## Comments on the Applicant's D3 Submissions

This document sets out the comments by Cambridgeshire County Council (**CCC**) and Fenland District Council (**FDC**) (together, **the Councils**) on the Applicant's Deadline 3 (**D3**) submissions. The tables below set out the document in question that the Councils are commenting on, together with the relevant paragraph or reference number.

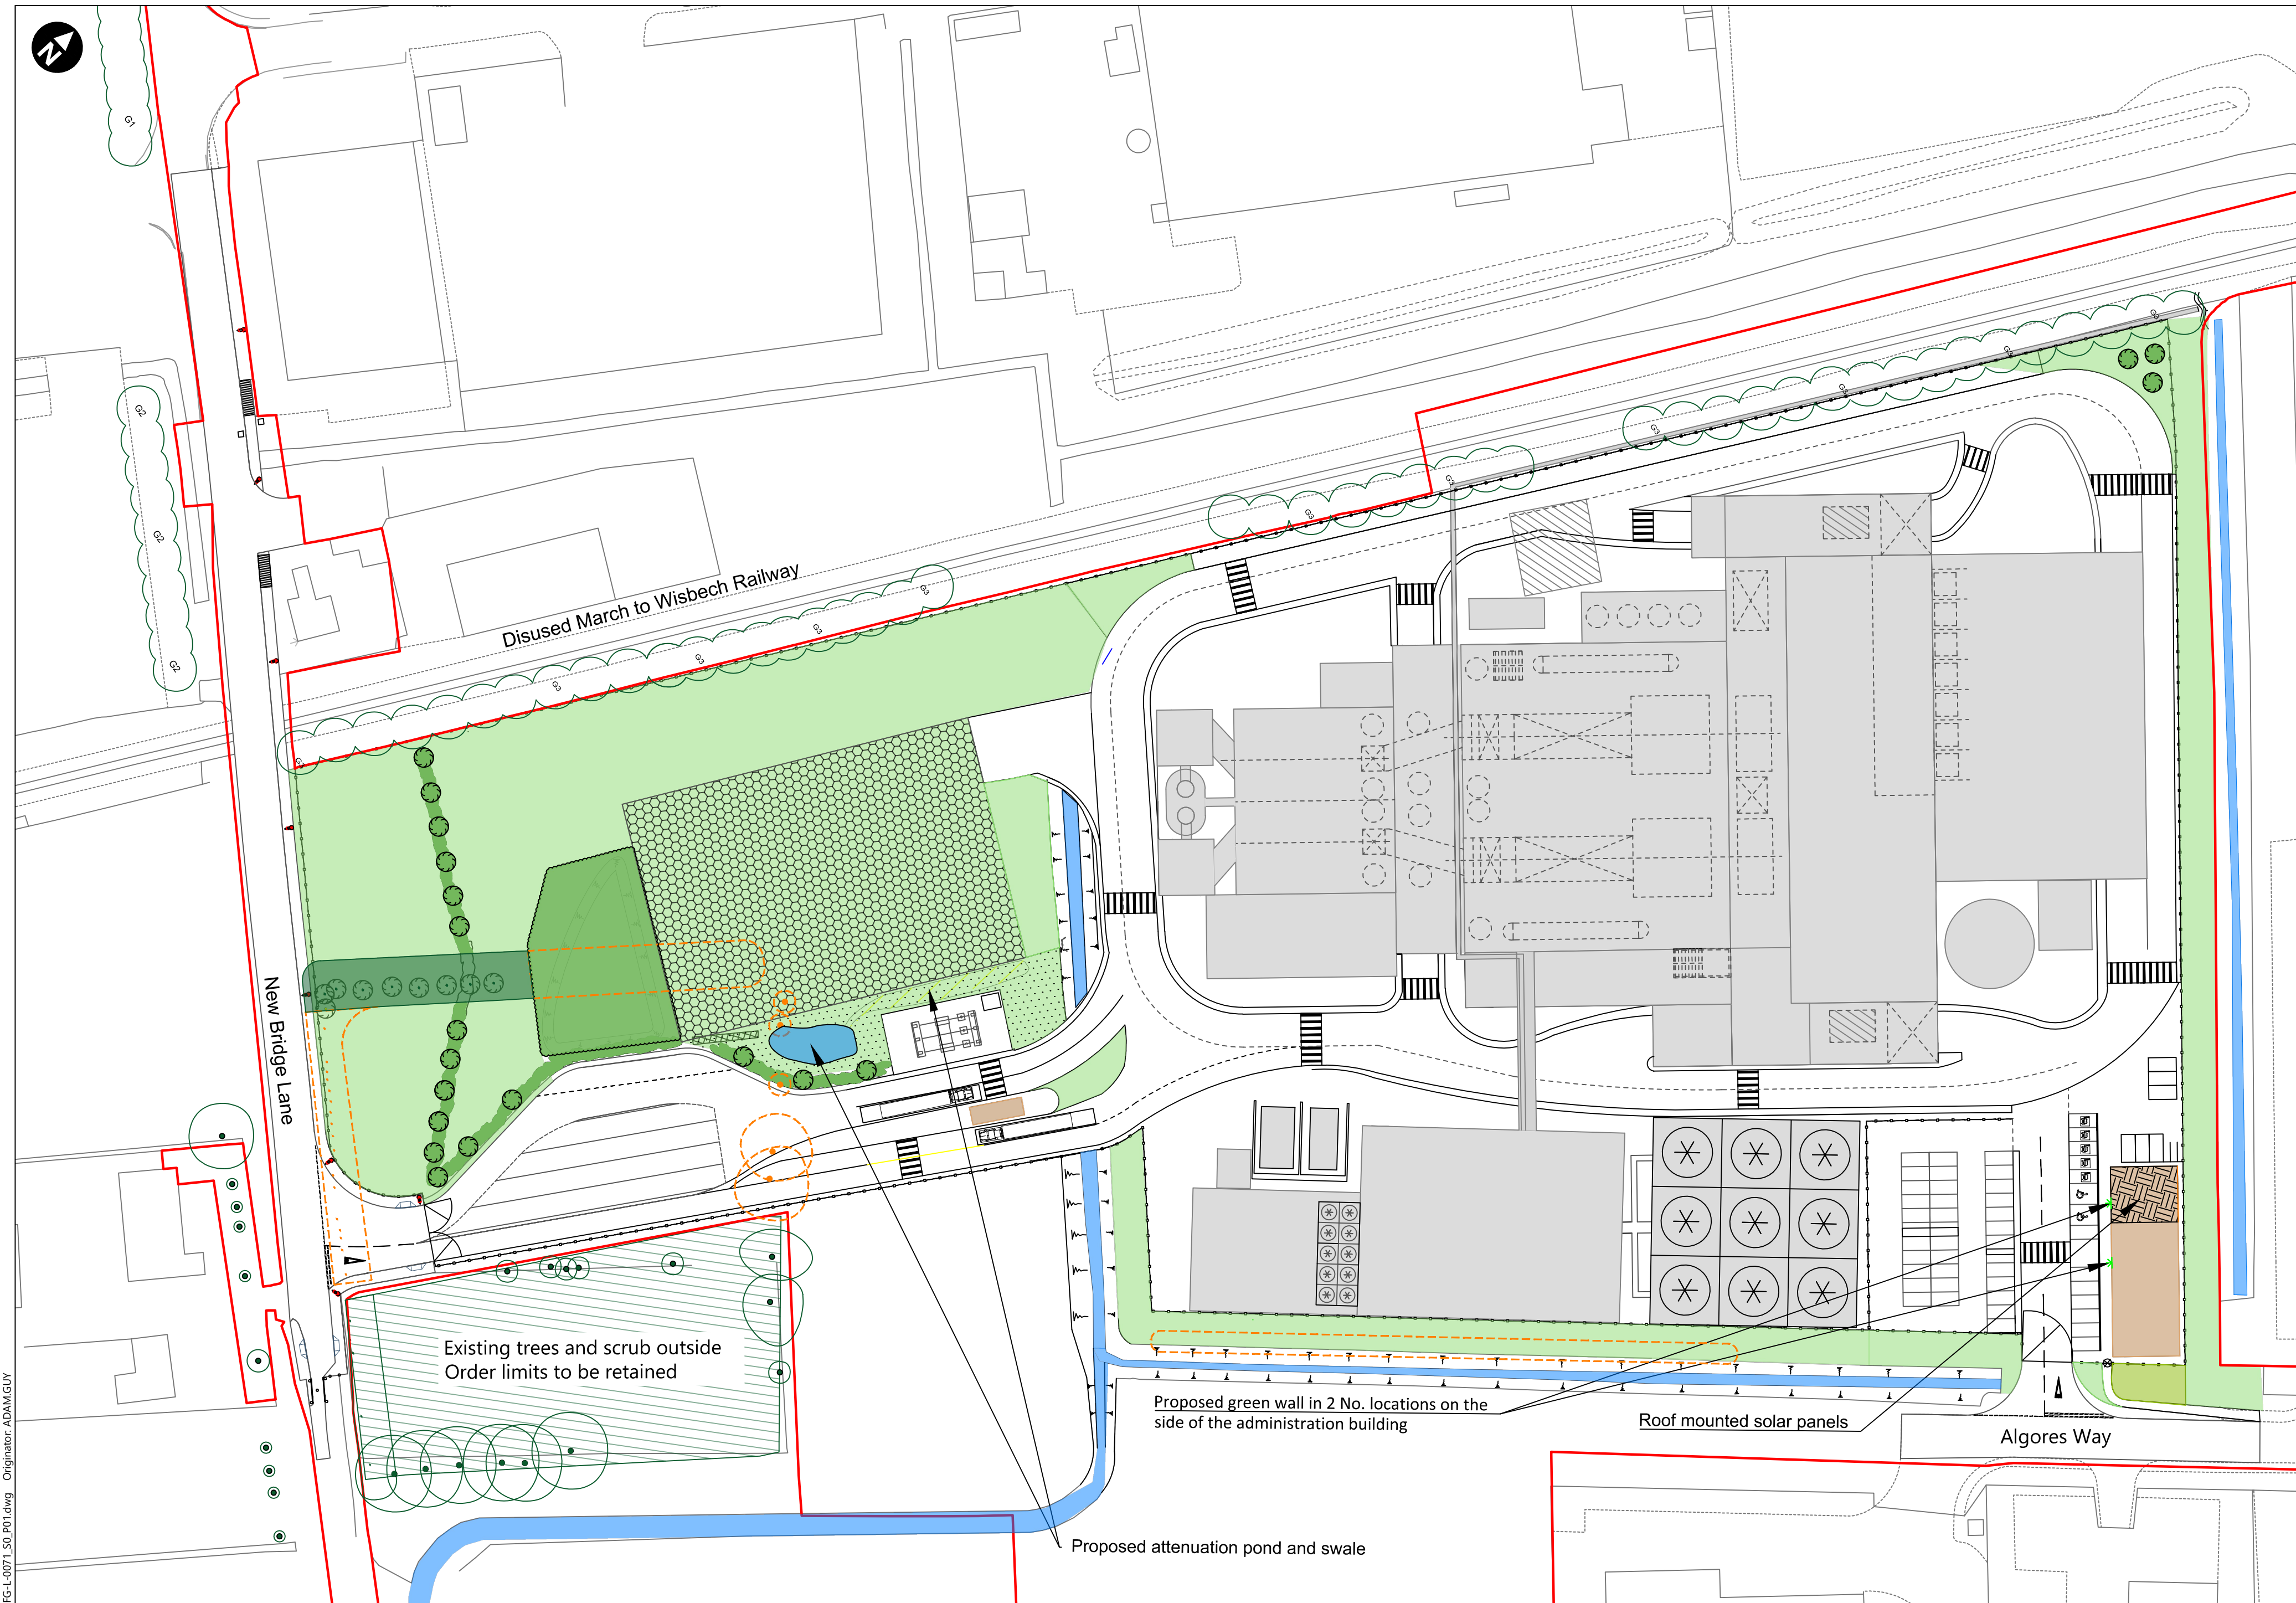
Outline Landscape and Ecology Strategy	Figure 3.14 (Appendix A)	<p>Figure 3.14 only shows proposed landscape scheme for a small proportion of the red-line boundary. It does not show temporarily lost / reinstated habitat, nor does it take into account habitat loss associated with highways works.</p> <p>The Councils request that Figure 3.14 is expanded to incorporate the entire red-line boundary and show all:</p> <ol style="list-style-type: none"> <li>trees/hedgerow that will be lost (including those associated with highways requirements – e.g. NMU/vehicle access);</li> <li>habitats that will be temporarily lost and re-instated; and</li> <li>habitats that will be created.</li> </ol>
--	--------------------------	---
